Martin Nugent
01254 828060
D3/12/0241

Drafted 10 April 2012

**Planning Application, Ribble Valley District
D3-12-0241 Chatburn Village Motor Co., Sawley Road, Chatburn**

Ground and First
Floor Layouts

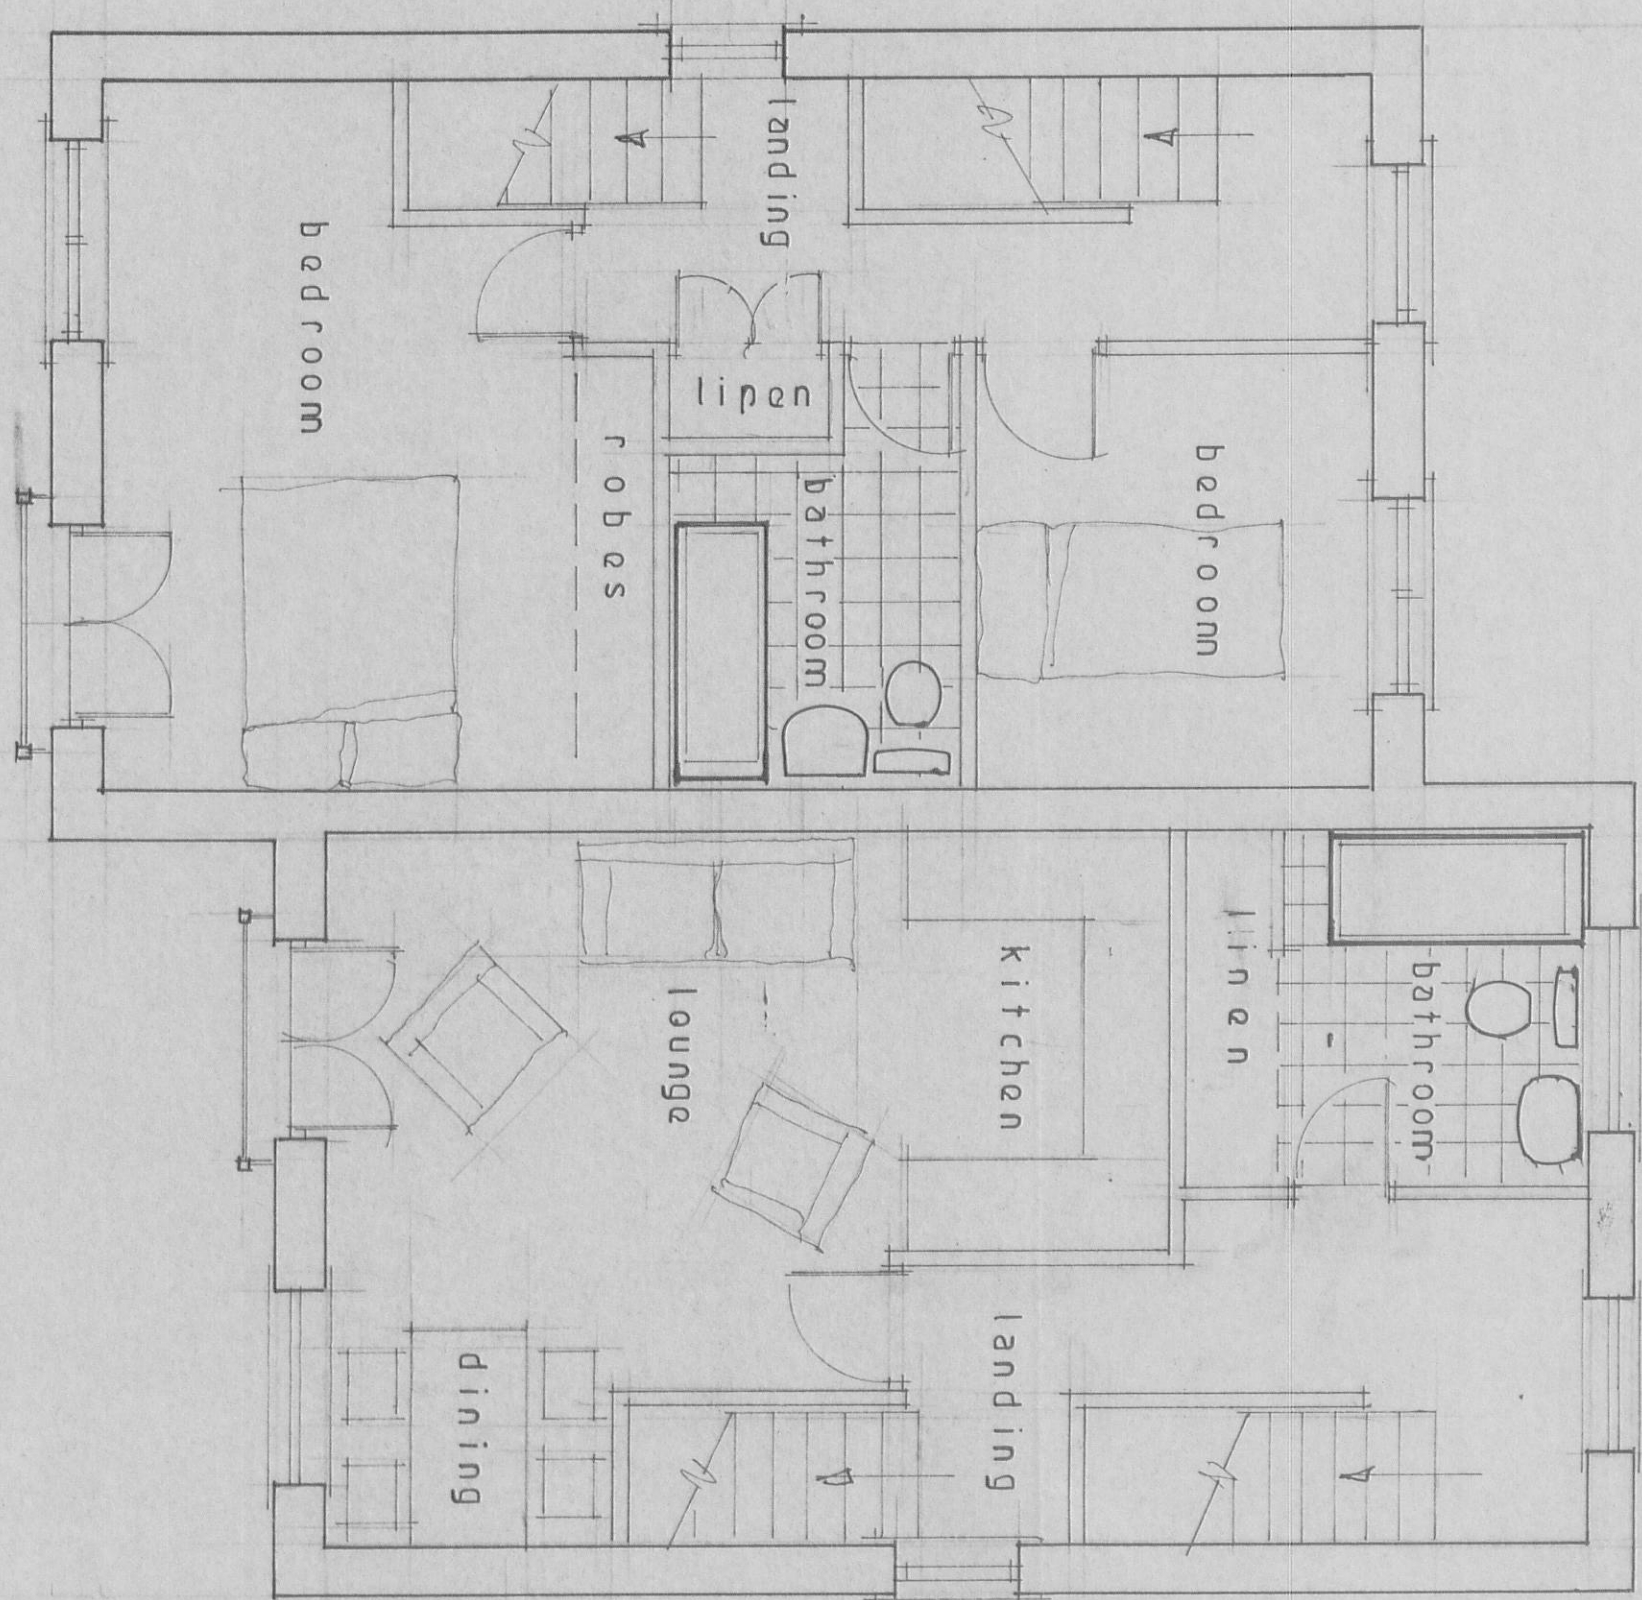
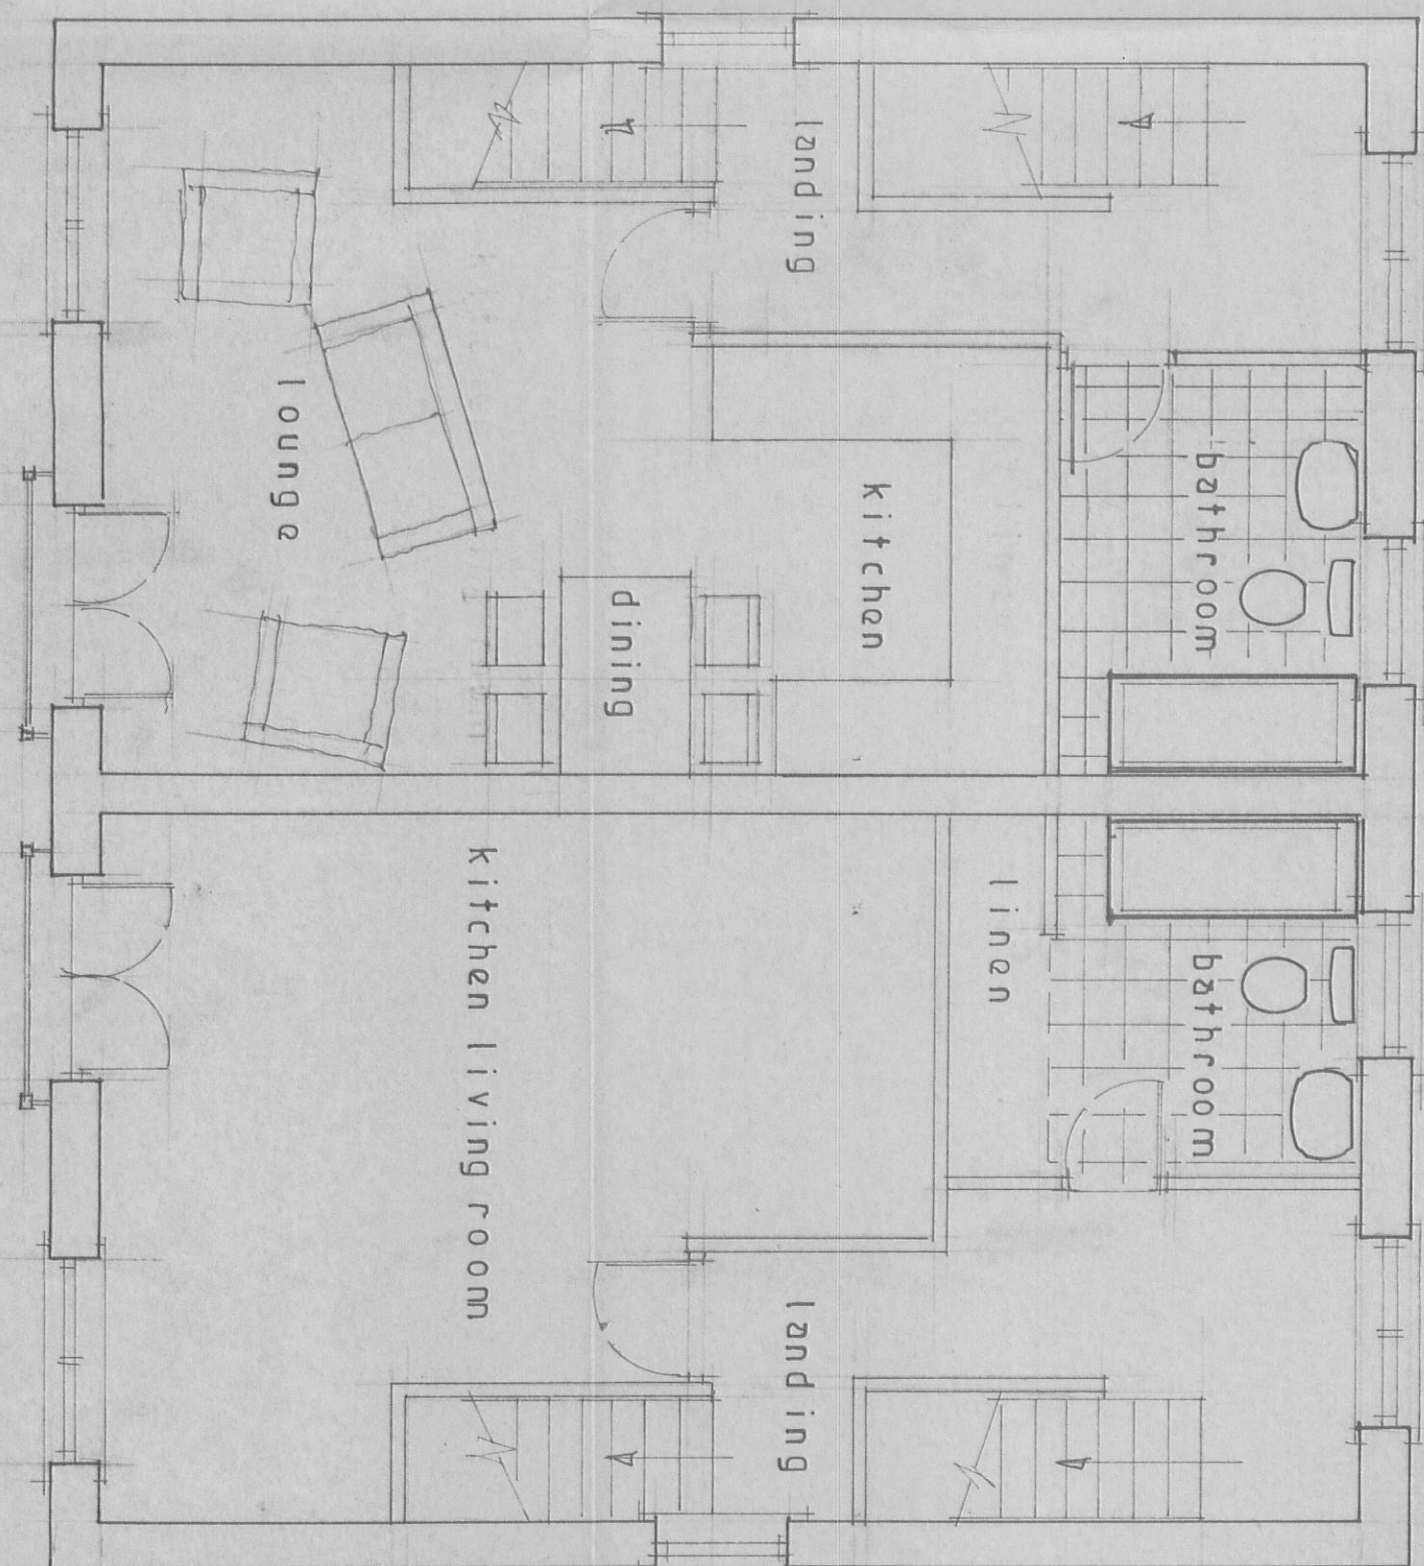
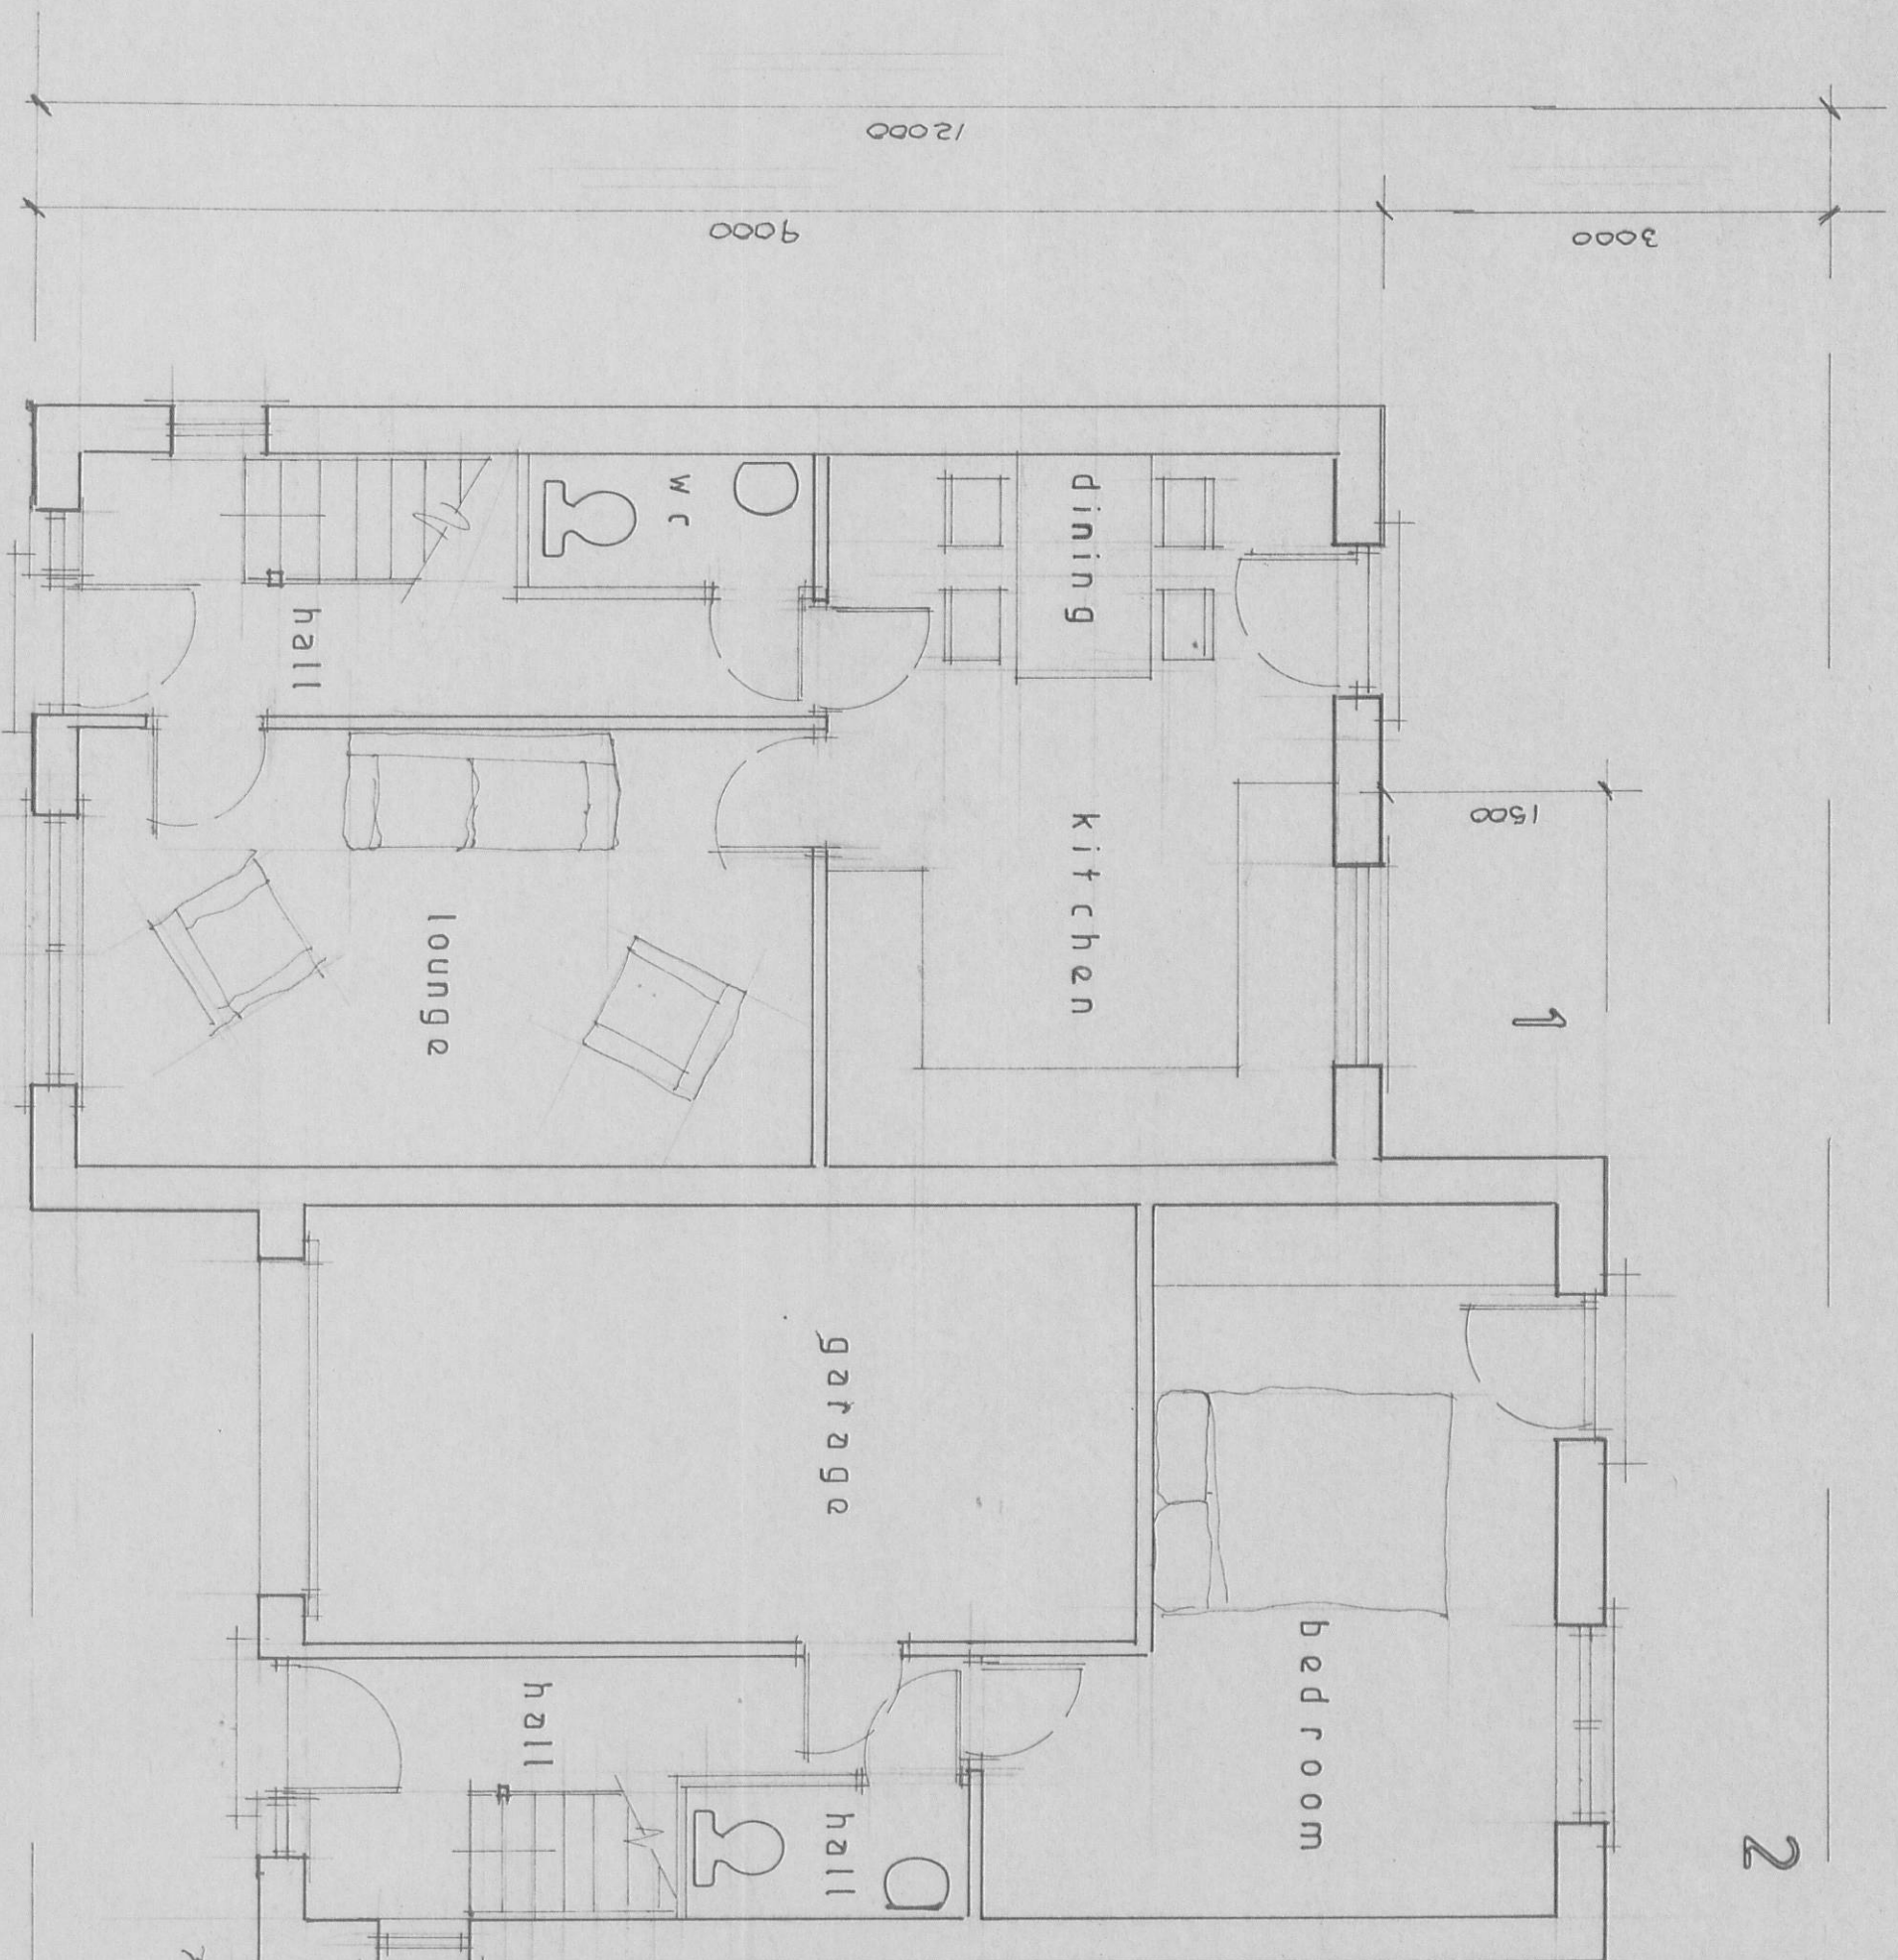
The revised plans identify an access from Sawley Road of 4.5m and off street parking for two vehicles at each unit. For three of the units, 2, 3 and 4, this includes one within an integrated garage and the other from the driveway. The garage dimensions are shown as 5.8m by 2.9m and the driveway provides a space of 5.0m by 2.5m. Both of these dimensions are satisfactory for the safe movement of vehicles.

In addition, as Unit 1 does not have an integral garage, there is a driveway and access to additional parking within the site.

I would recommend that a Condition be attached to any successful application that seeks to retain the use of the garages for their intended purpose and to prohibit their future conversion to residential living space.
